**Addendum No. 1**

RE: Contract # C204714

**Cabarrus County (B-5810)**

BRIDGE #22 OVER ROCKY RIVER ON EASTBOUND NC-24 AND NC-27

PROJECT REFERENCE NO. <i>B-5810</i>		SHEET NO. 6
RW SHEET NO.		
ROADWAY DESIGN ENGINEER	HYDRAULICS ENGINEER	
<b>DOCUMENT NOT CONSIDERED FINAL UNLESS ALL SIGNATURES COMPLETED</b>

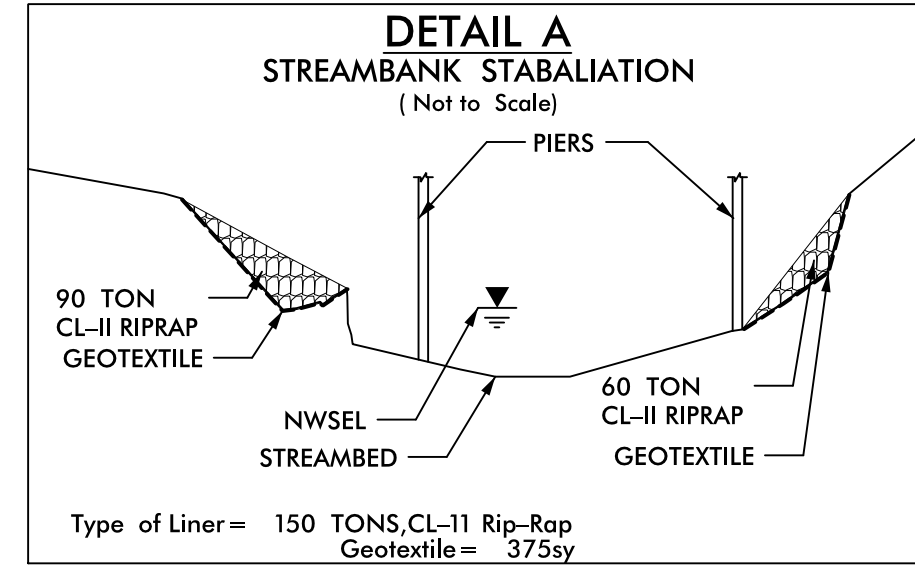
Sheet No.	Revision
3D-1	Revised to reflect quantity change shown below

PROJECT REFERENCE NO.	SHEET NO.
B-5810	EC-13/CONST.-6
RW SHEET NO.

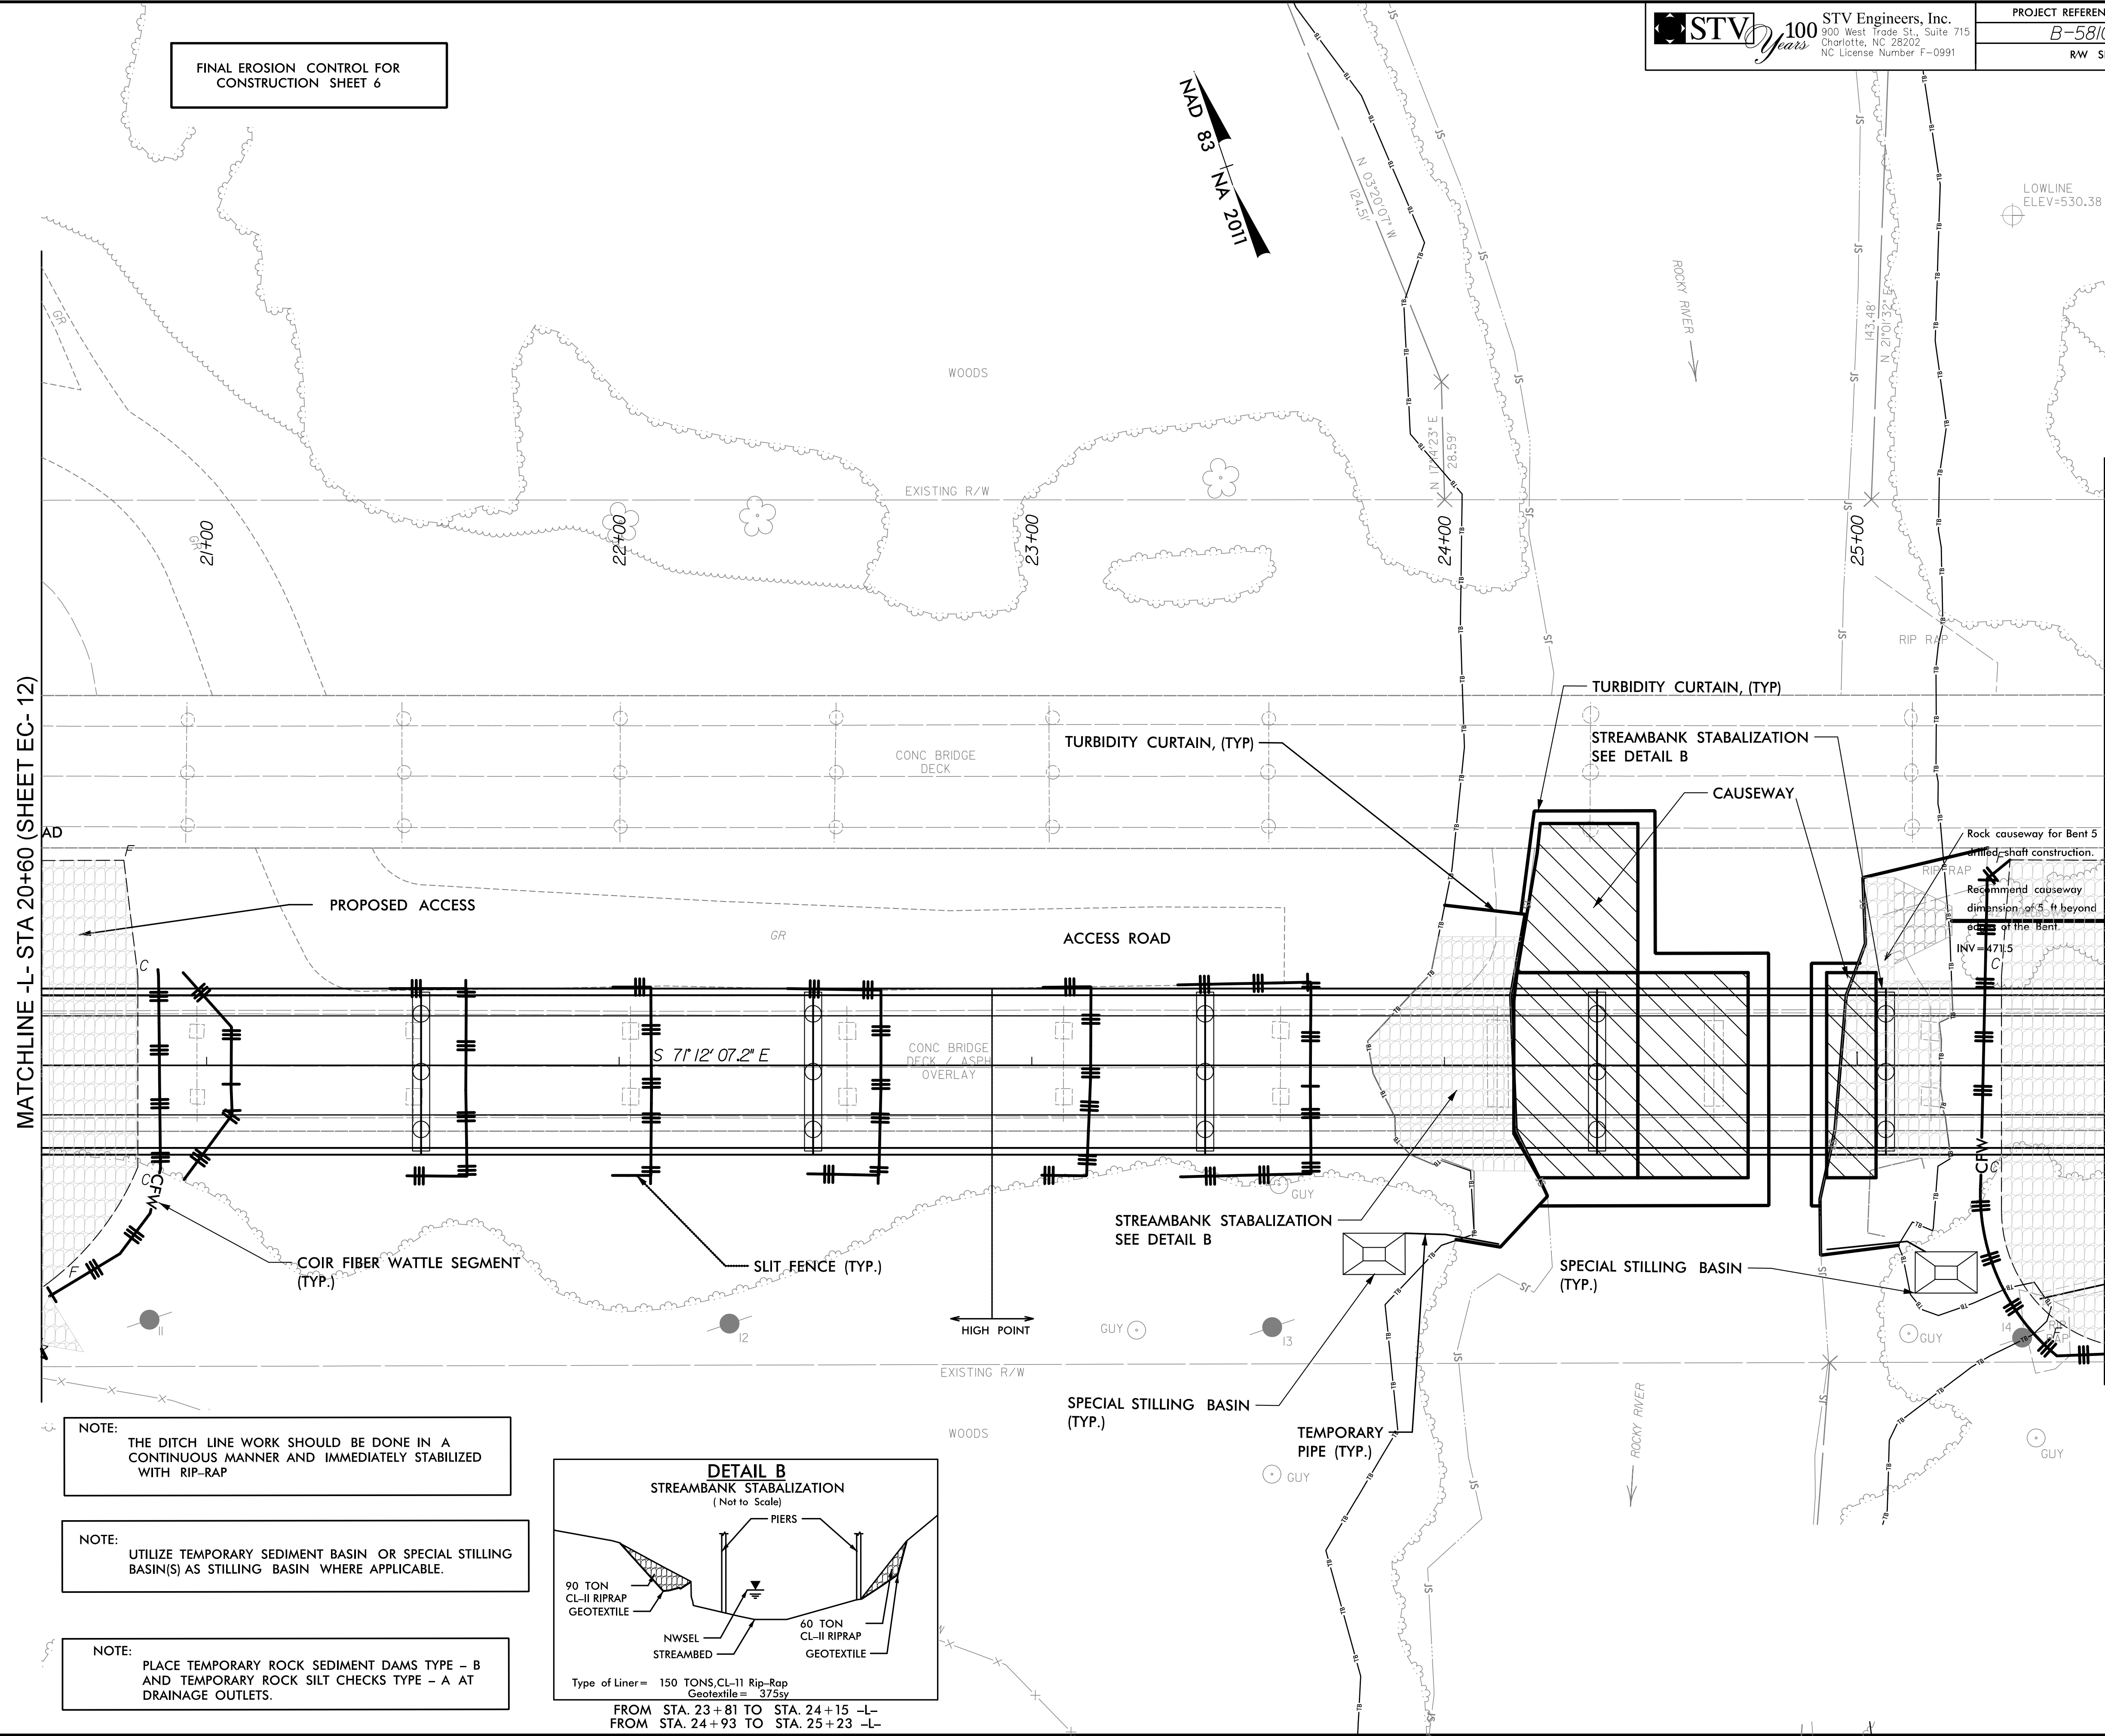
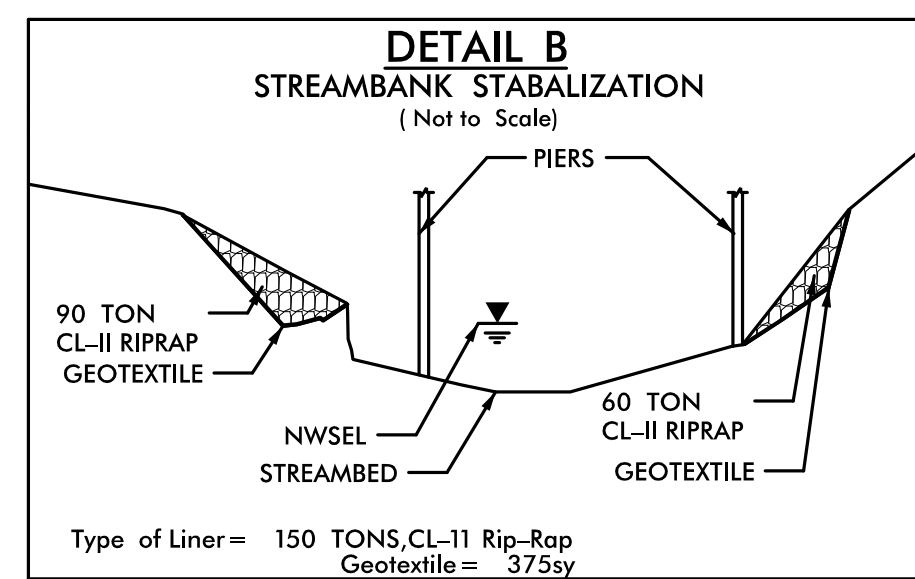
Sheet No.	Revision
EC-5	Revised to add note and remove impervious dike
